CITY OF ALBUQUERQUE

February 4, 2021

RE: 8900 Eagle Rock NE
Grading and Drainage Plan
Engineer's Stamp Date: 12/17/20
Hydrology File: C20D087

GRADING AND DRAINAGE PLAN

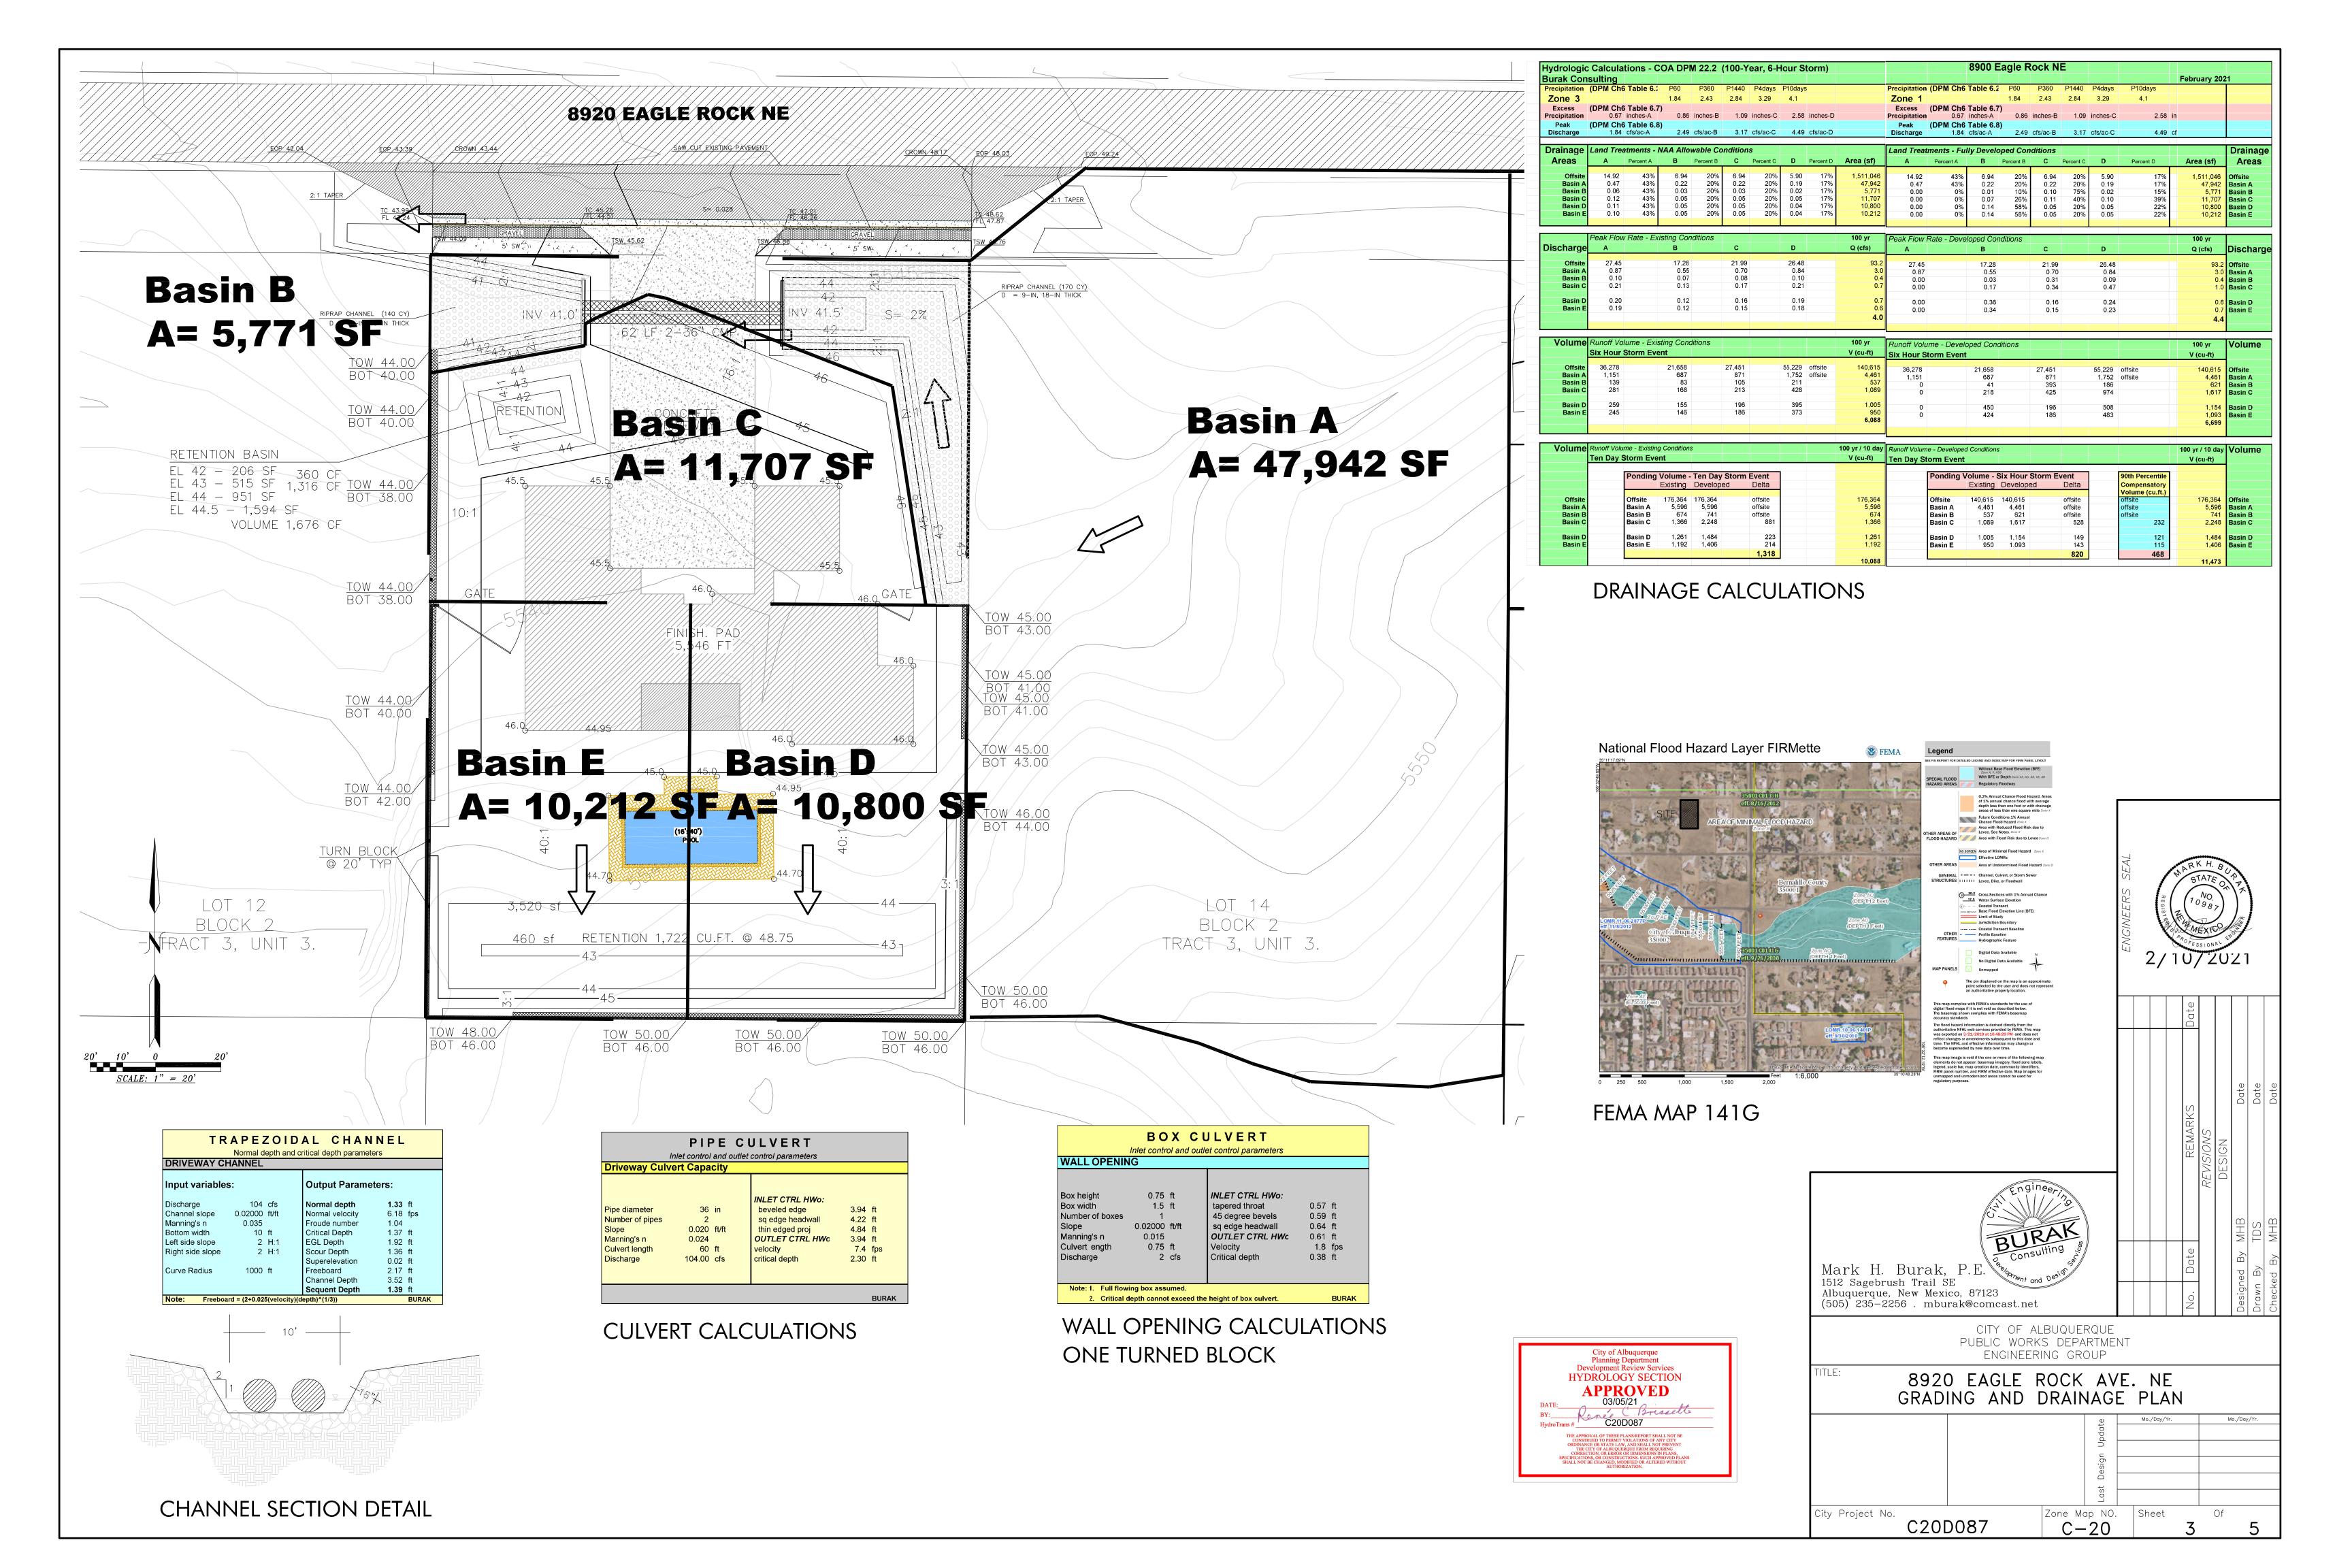
1. Per the IDO § 6-4(Q), the property owner of the property is responsible for building the adjacent half of Alameda Blvd. to include curb & gutter, and sidewalk. The project will have to go to the DRB for approval of the Infrastructure List which will have to be financially guaranteed.
2. Per Item #1, please show the proposed street improvements to include curb & gutter, and sidewalk.
3. Per the North Albuquerque Acre MP, all properties along Eagle Rock are to drain towards the R.O.W. Drainage will then be conveyed to the west to an existing storm drain system. Please redirect the drainage to Eagle Rock. If need be, please use a turn block to allow drainage from the back yard to the front yard. Please provide a typical detail for the turned CMU block. This block needs to be at least four (4) inches above the proposed grade to avoid clogging.

4. That being said, I do not need to see the whole drainage area (which is area 111.1 of NAAA MDP). Just the current site is sufficient. If you need to show off-site drainage flows, then just include an arrow with the Q for that flow.

5. The vicinity map provided is the County's Zone Atlas, since this site is in the City please use the City's Zone Atlas which can be downloaded in pdf format from the City of Albuquerque's website.

6. Please enlarge all calculations so that they can be readable. All calculations still need to be reviewed once they become readable. The standard text height is 0.10. Also, please just use black & white for the pdfs. Color is very hard to read and it is against drafting standards.

7. Please note that you are still referring to the old DPM. Please use the procedure for 40 acre and smaller basins as outlined in Development Process Manual (DPM) (signed 06/08/20) Article 6-2(a).
